PLOT PLAN / PLANTING PLAN

0 NEVADA LANE
COLORADO SPRINGS, COLORADO

FILE NO: VA 182

PLOT PLAN / PLANTING PLAN

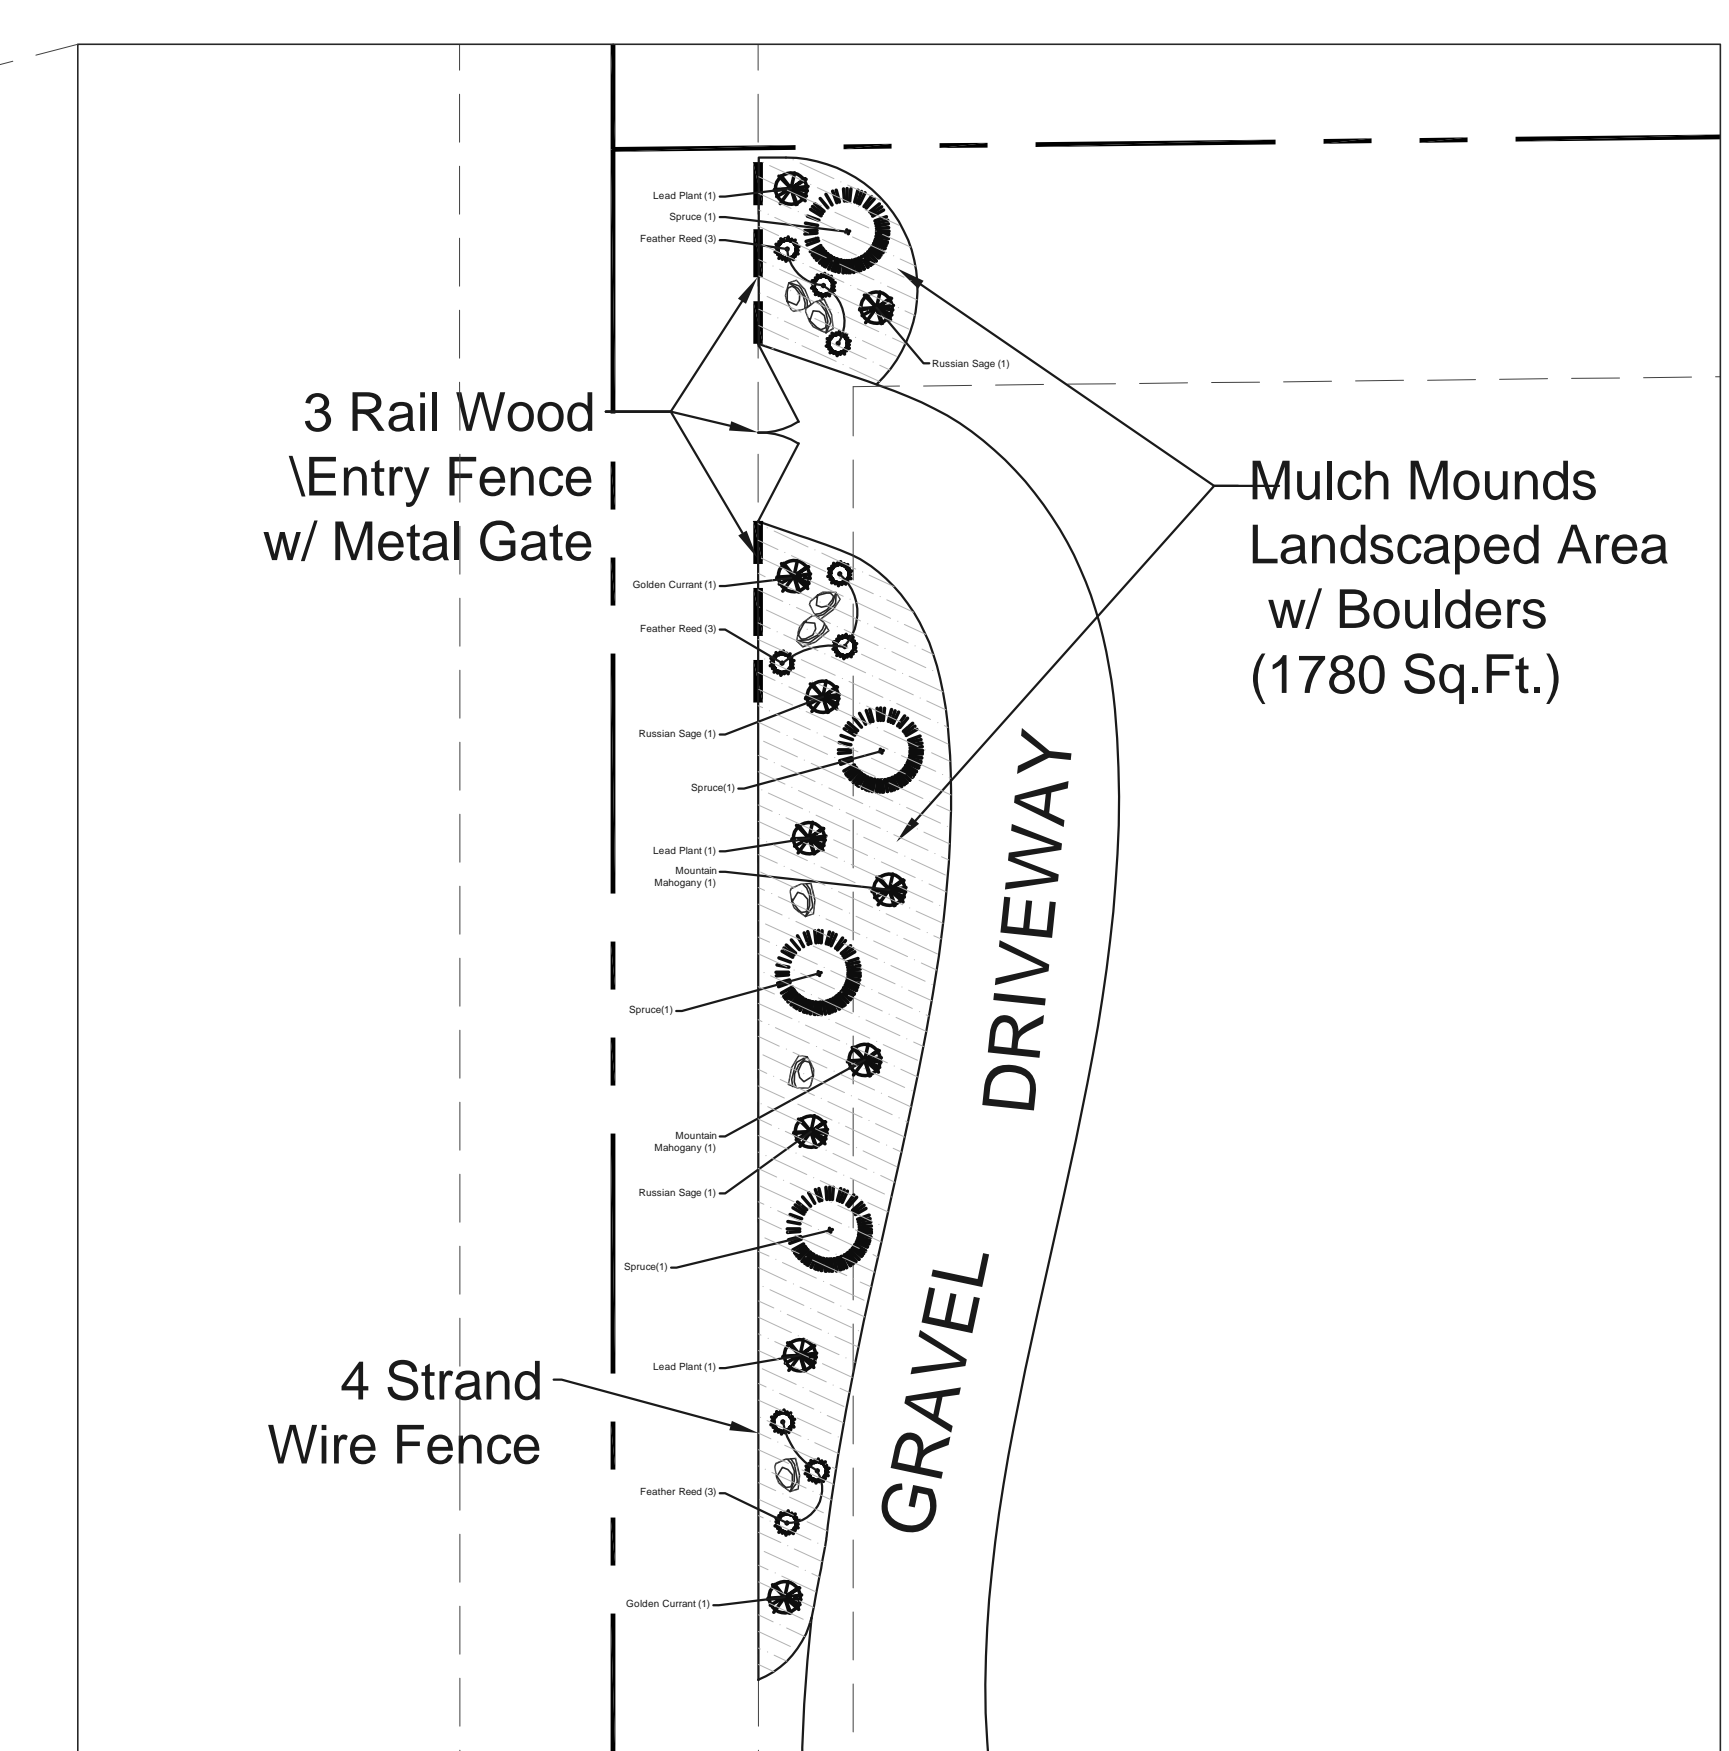
This should show a 10 foot landscaping buffer with 1 tree per 30 feet of frontage.

Internal landscaping requirement is 5% of total parcel size. (if this is native ground cover show that as landscaping).

This needs to be buffered. 15 feet buffer with one tree per 25 feet of frontage, and a 6 foot opaque fence.
